Application No: H13-0924-25 **Applicant:** Allison Homes Ltd.

Proposal: Erection of 86 dwellings and associated works - approved under H13-0483-24. Amendments to House Type 1206 to remove porch

Location: Land North Of: Roman Road Moulton Chapel Spalding

1206 ELEVATIONS

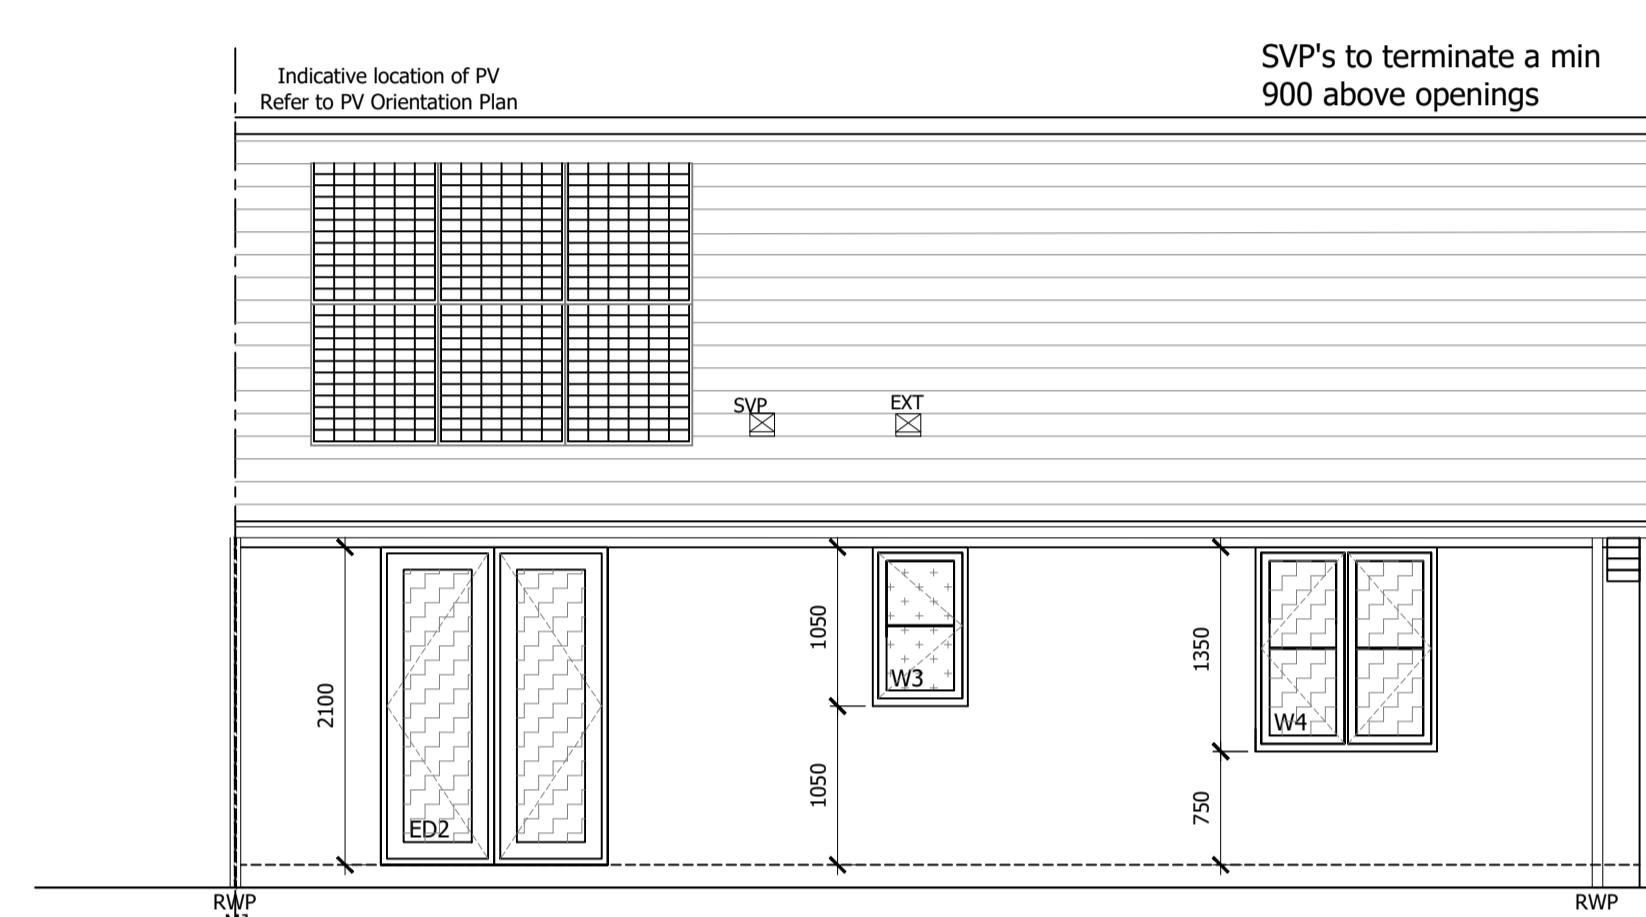
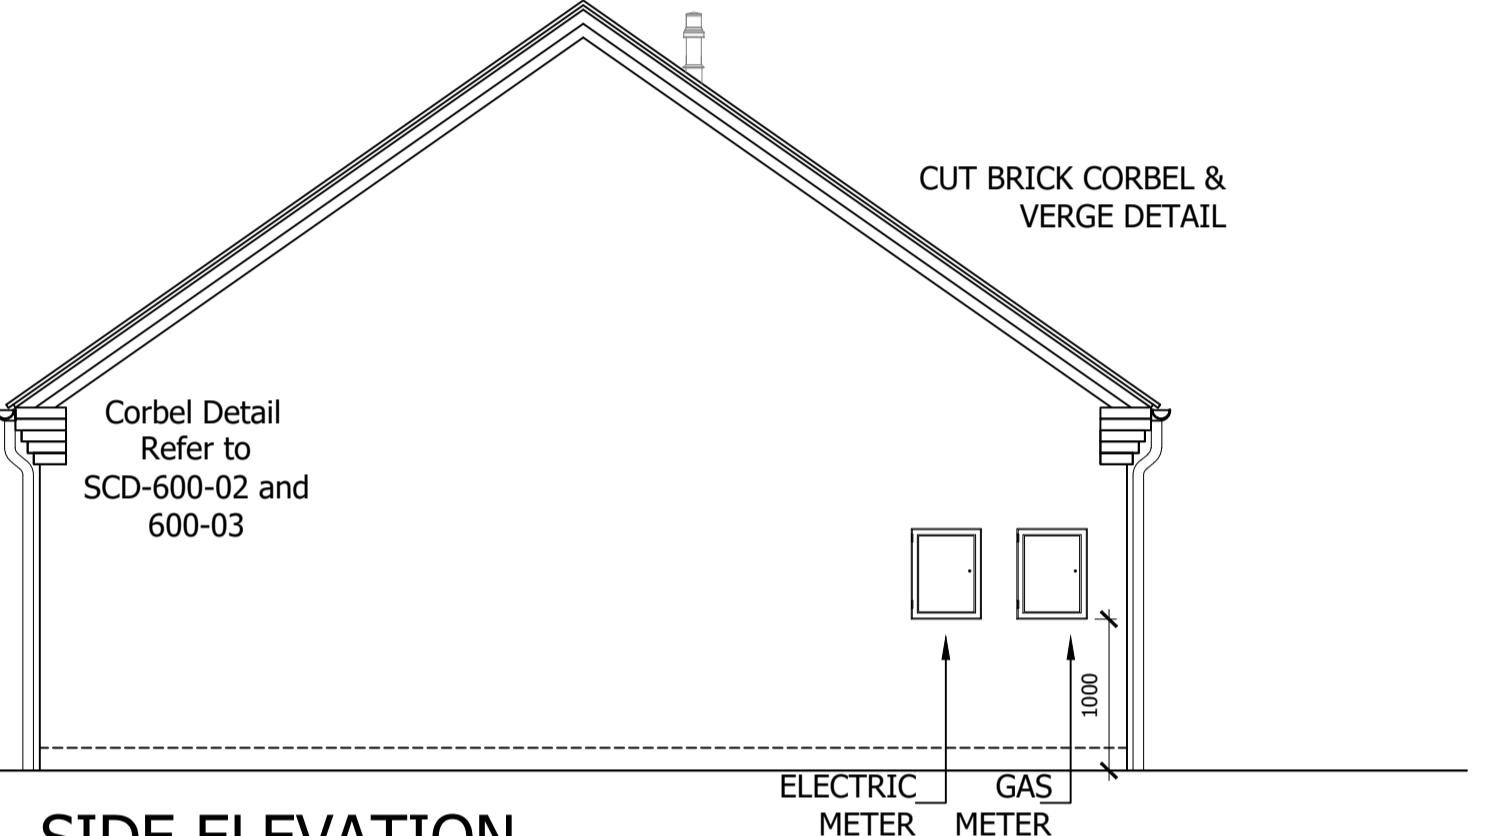
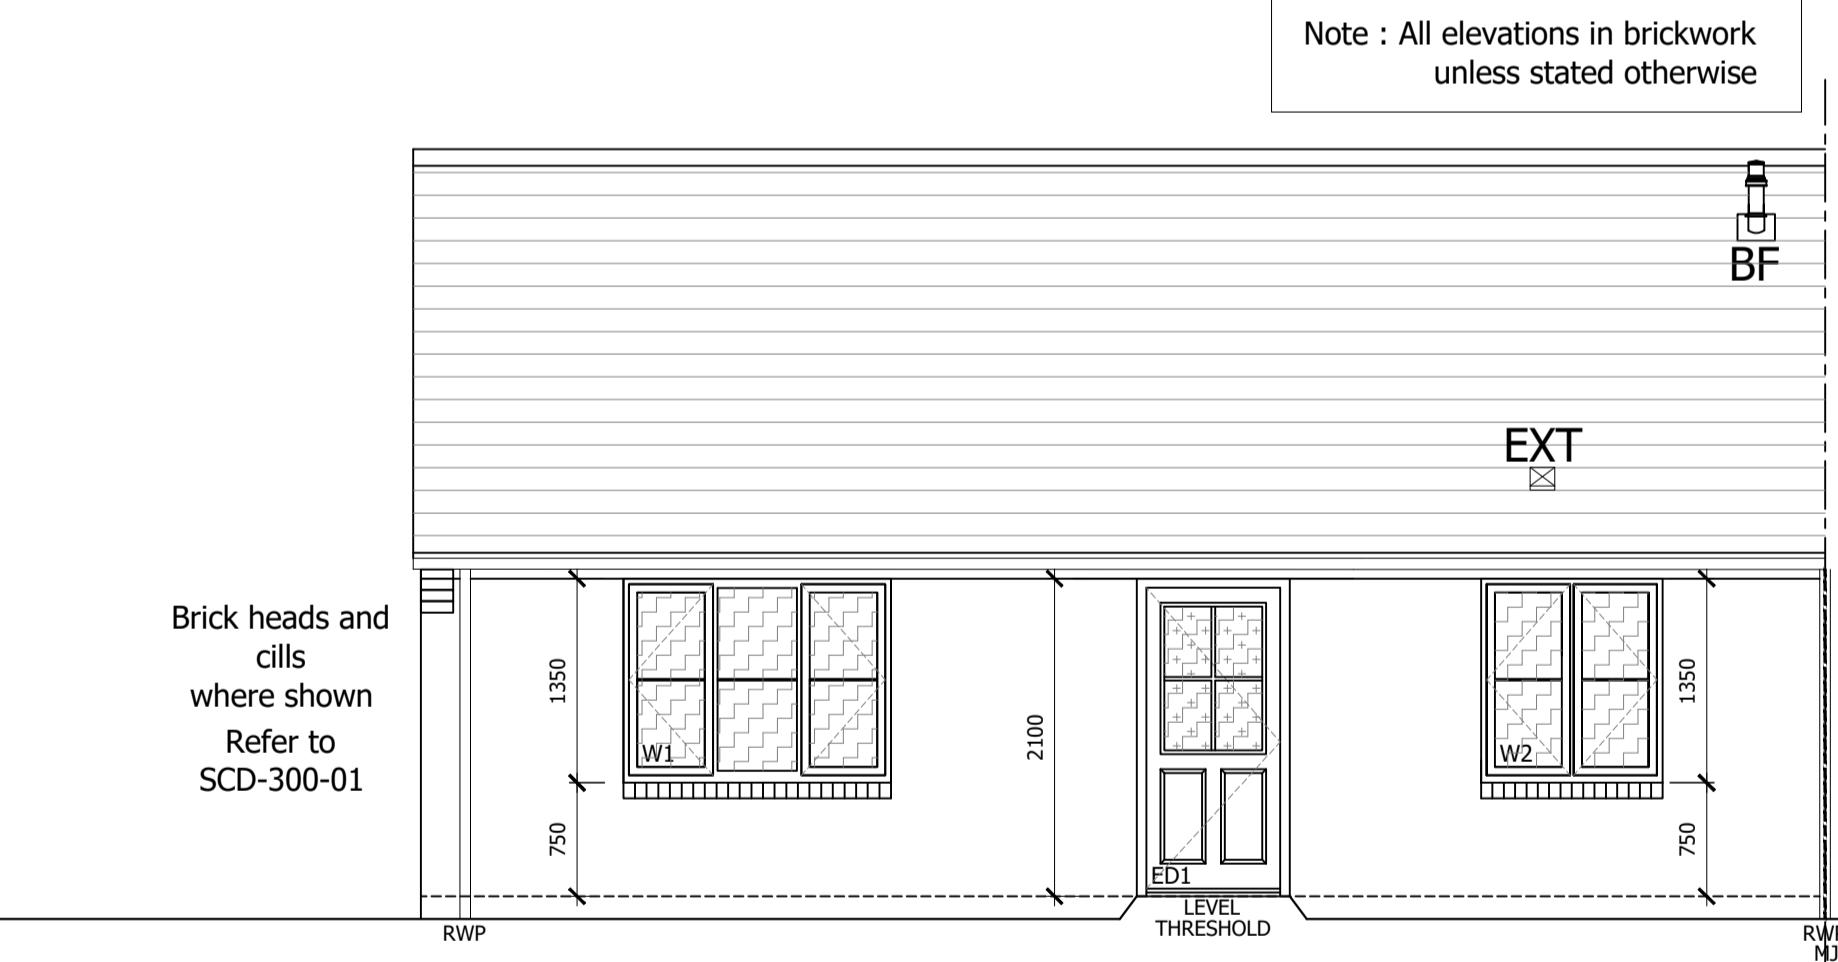
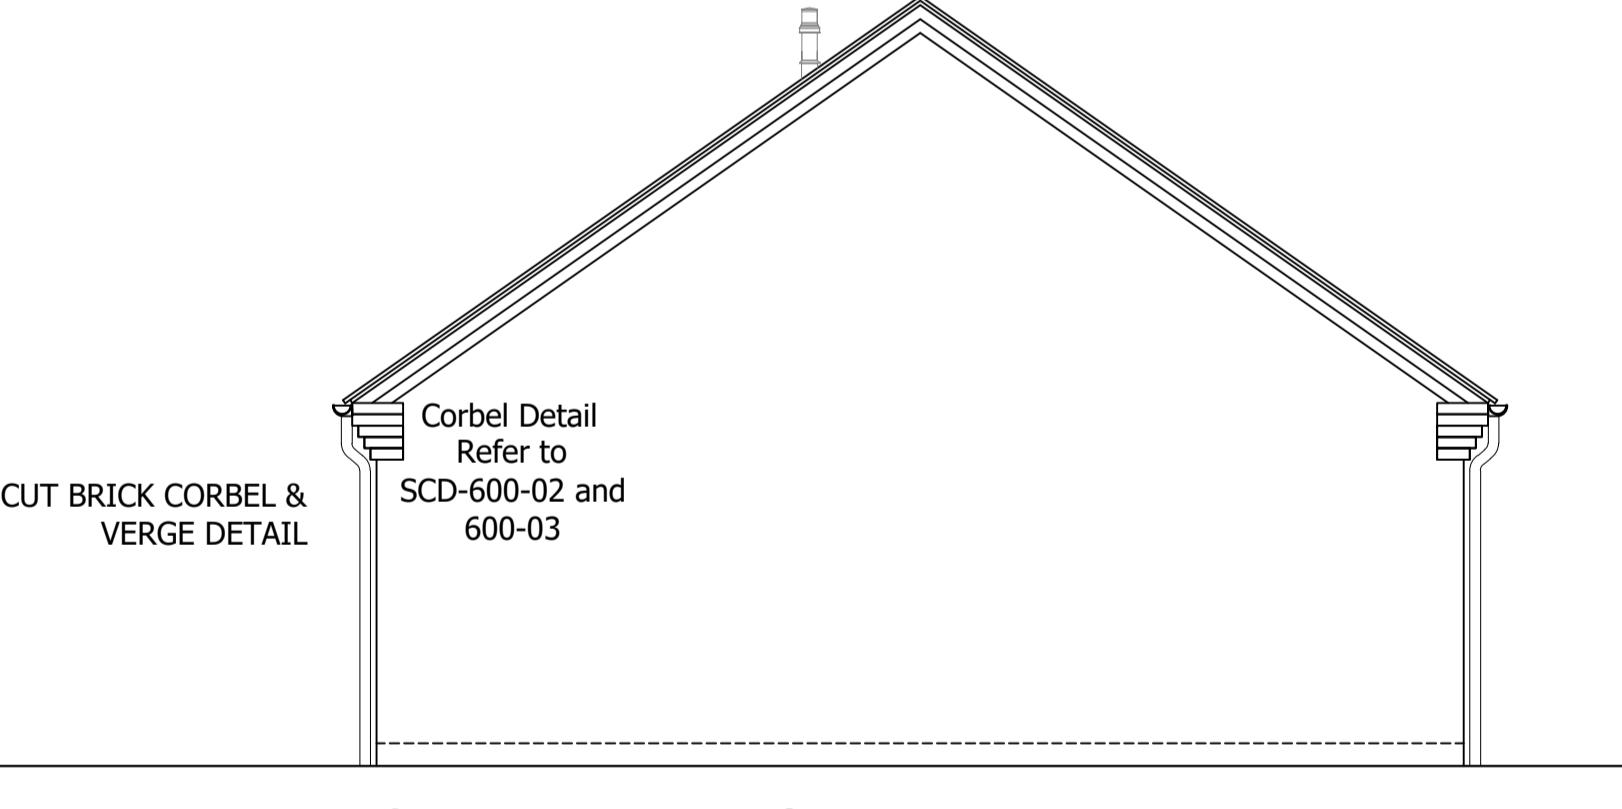
Under this application the applicant seeks to alter the approved House Type Drawing 1206 to remove the porch.

Removal of porch canopy and supporting corbels.
